Cottam – Sturton by Stow Parish Council

During the hearing in August, Sturton by Stow Parish Council asked why the entire hedgerow along Thorpe Lane to Thorpe Bridge needed to be removed.

Figure 0.1% Annual Probability Scenario Depth Map

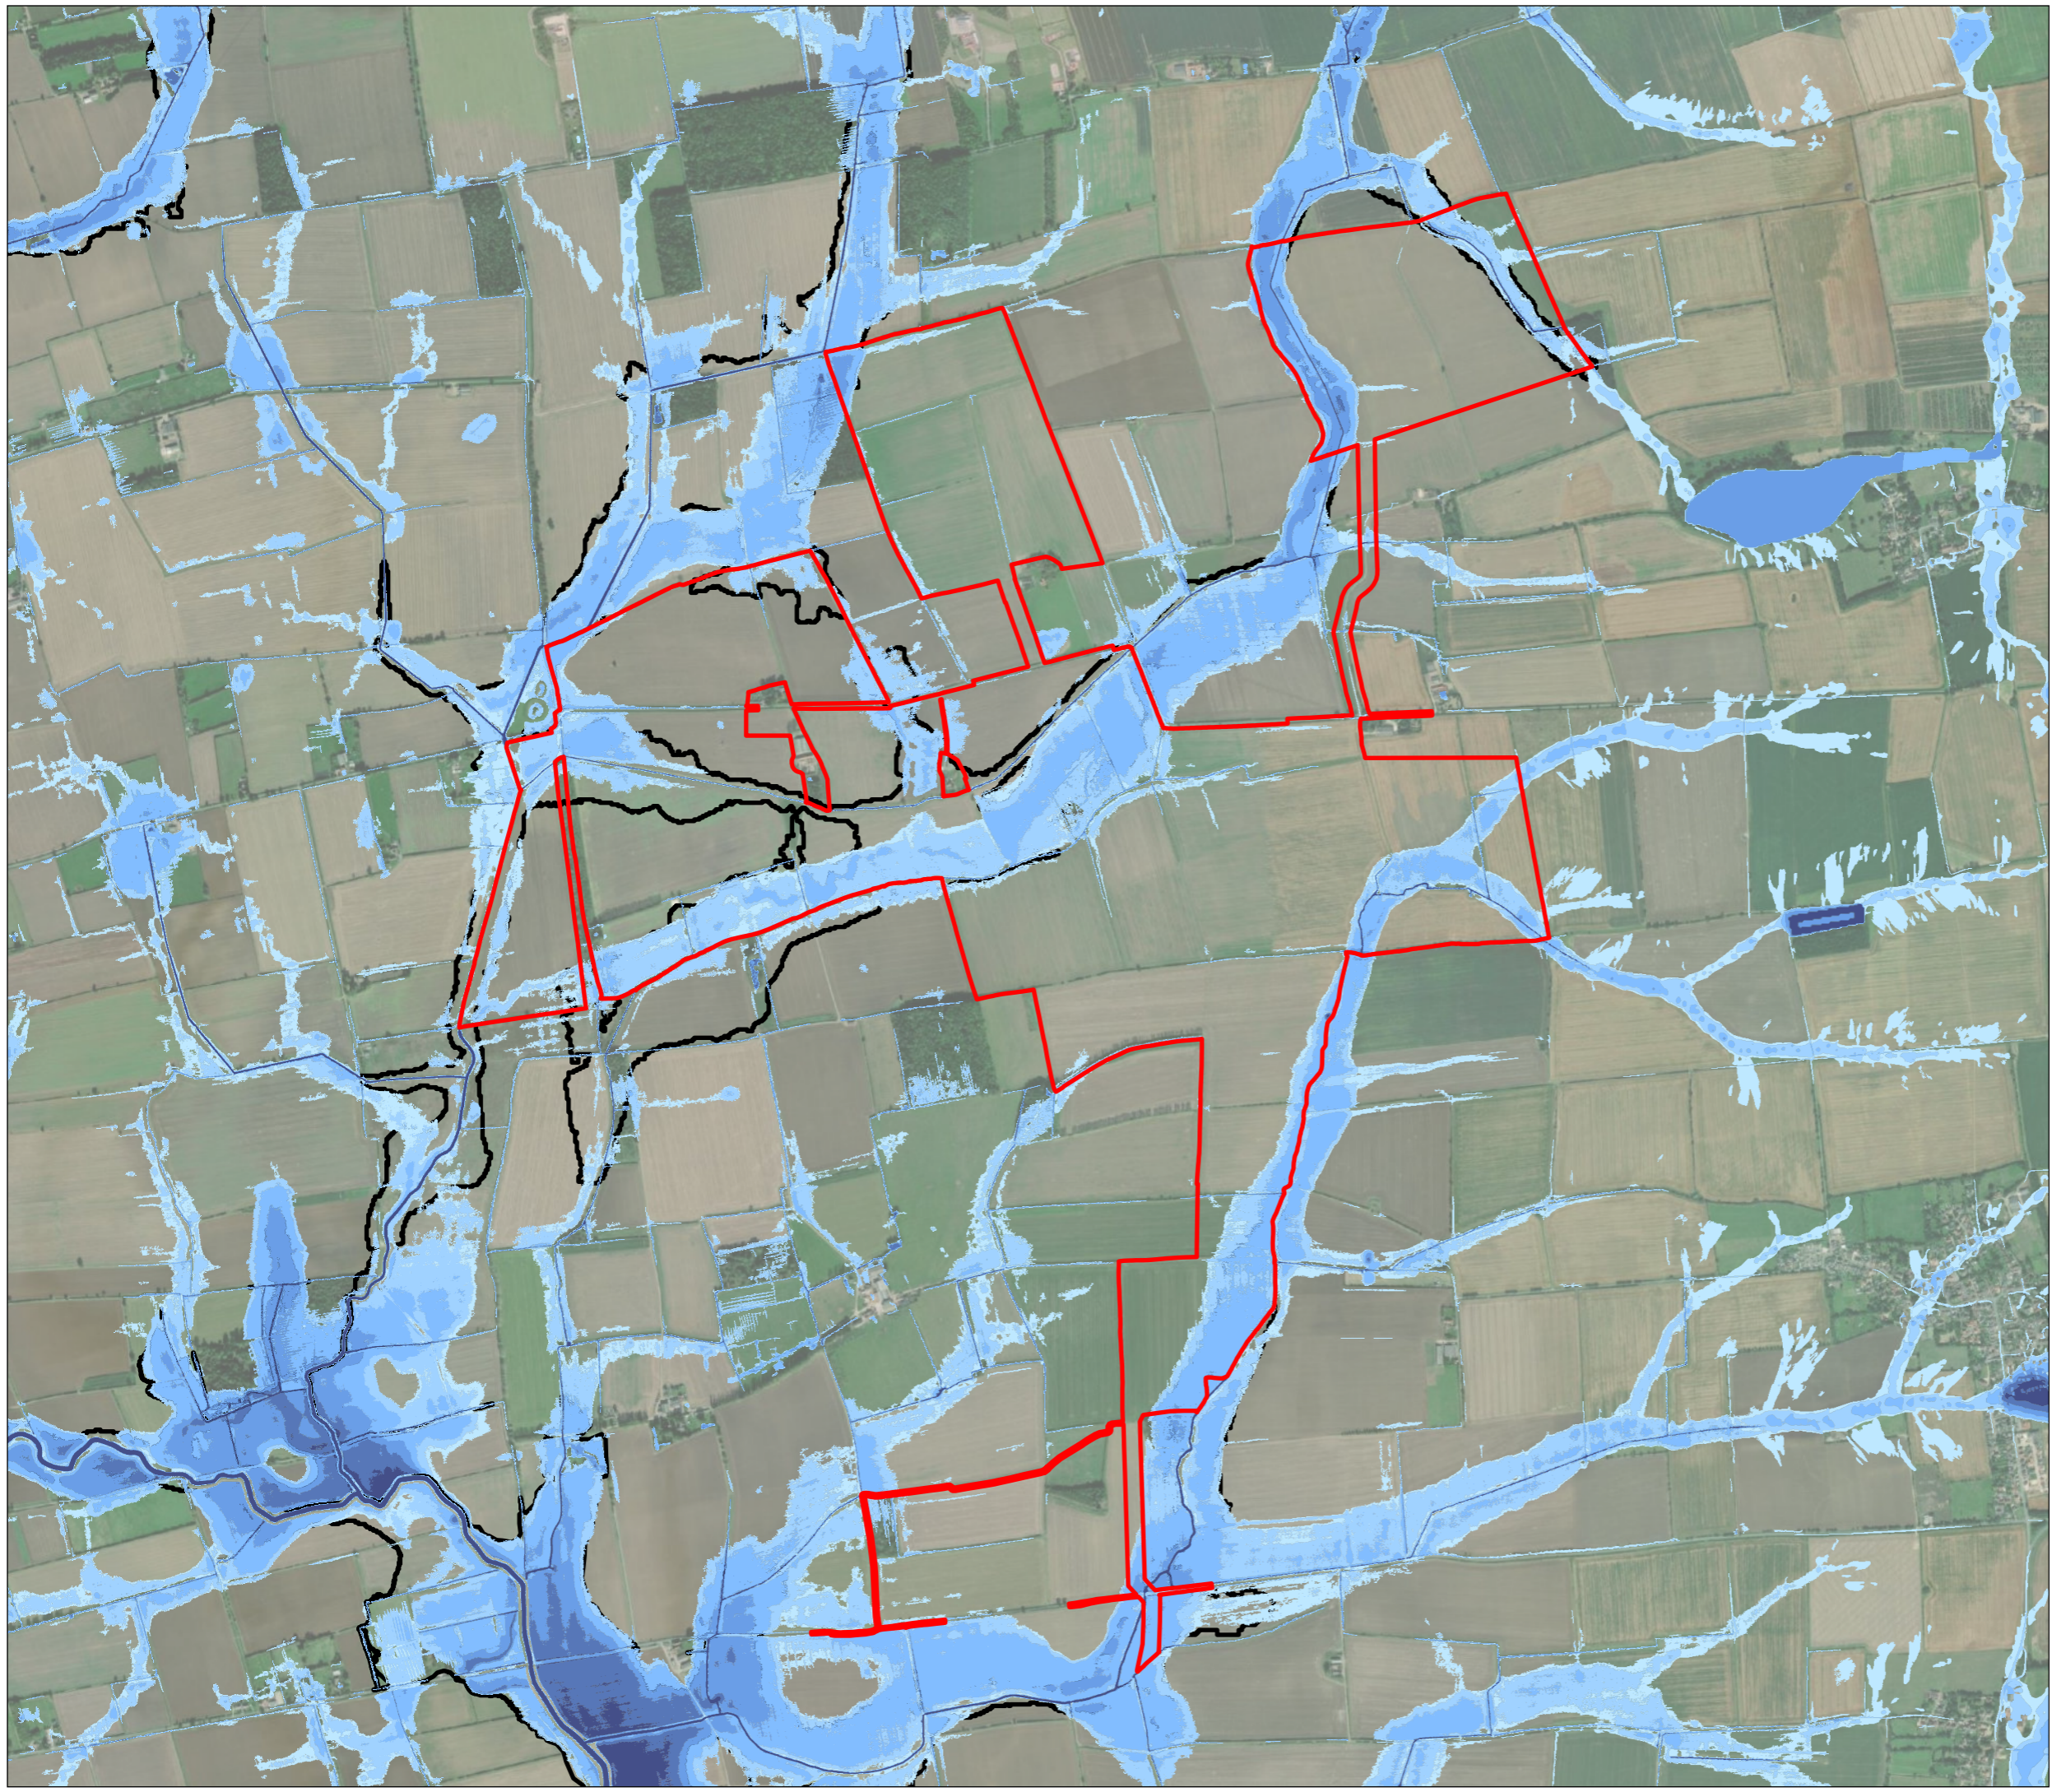
5. Land proposed for Cottam 1 was significantly flooded along with the surrounding areas. Is the applicant aware that the term 'negligible' in response to flooding is incorrect for the land along River Till?
